DRB Application No.: 03-00203 (P&F)
Project Name: SANDIA GLOW SUBDIVISION
Agent: HARRIS SURVEYING

CITY OF ALBUQUERQUE
Planning Department
Development Review Board Comments
February 19, 2003

RE: Sandia Glow Subdivision, Lots 2A-18A/ XSIA to Defer Side, Vacation of Private Easements, Prelim & Final Plat

SANDIAGLOW.DWG(FEB-02)

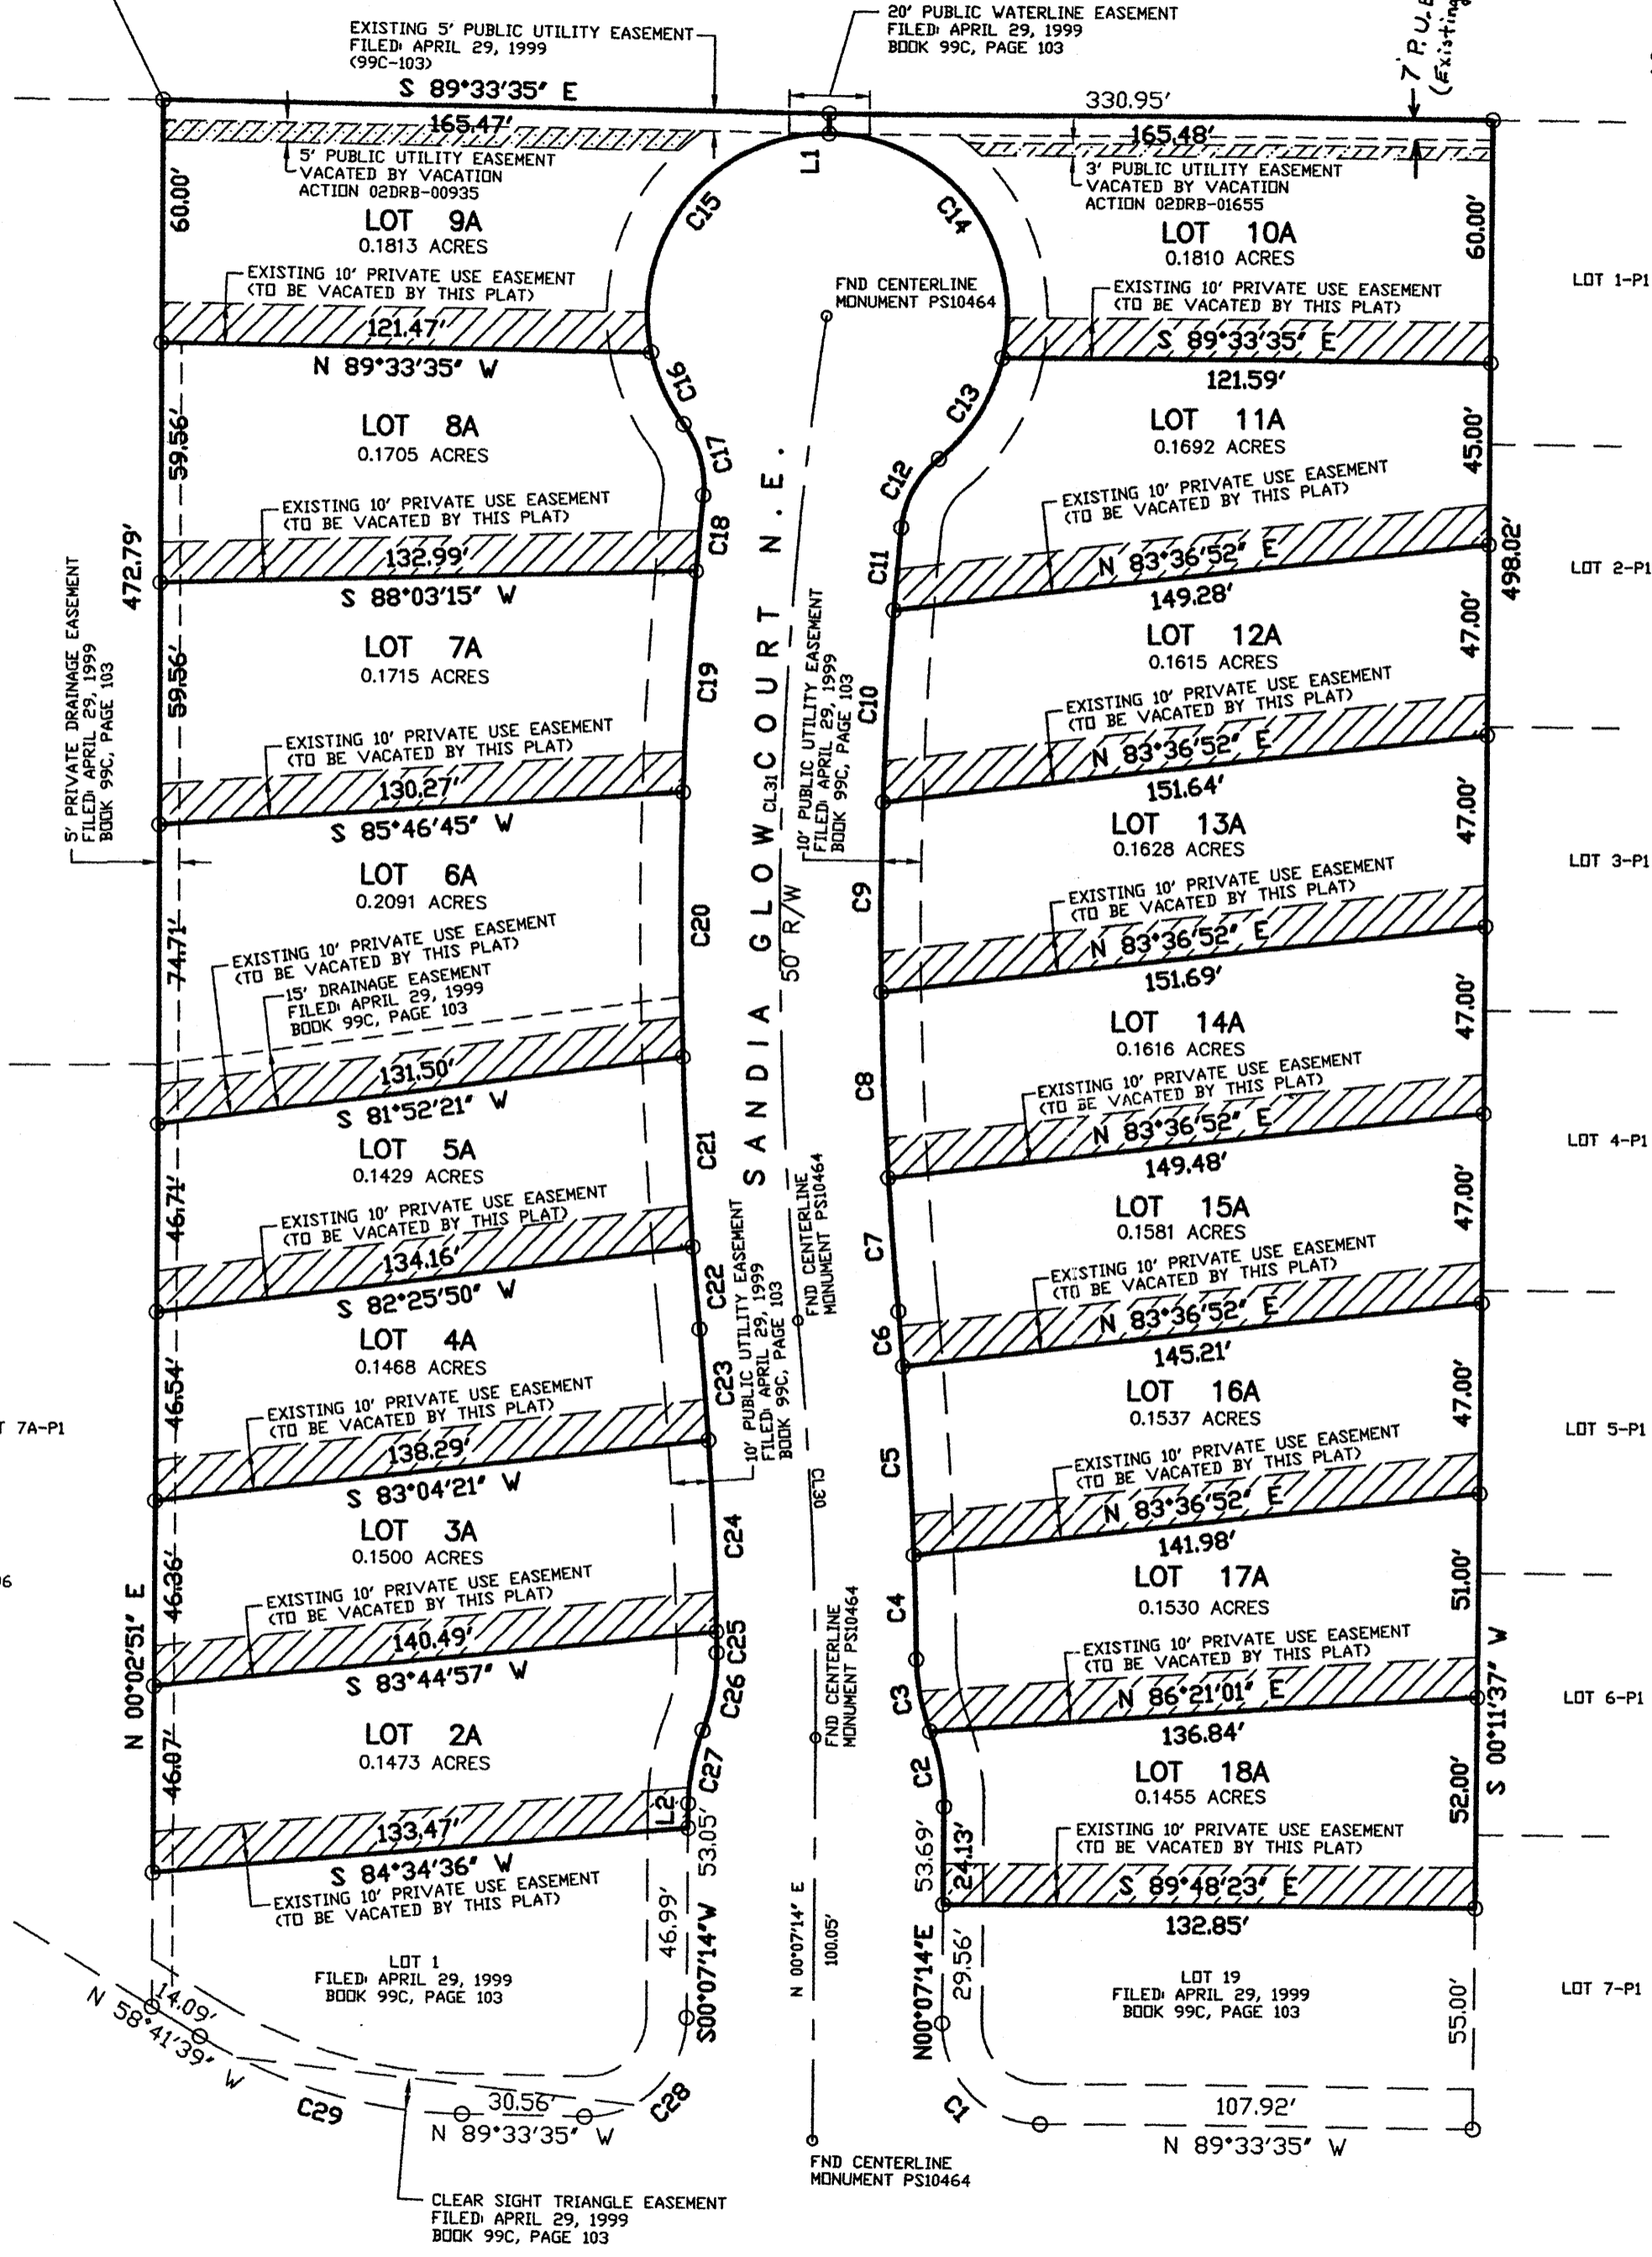
Need site sketch of what is built to approve vacation.

The Hydrology Section has no objection to the subject request.
 Need to see who the beneficiary was on the original plat.

No.	Comment
<input type="checkbox"/>	What are the easements for?
<input type="checkbox"/>	No adverse comment on the plat.
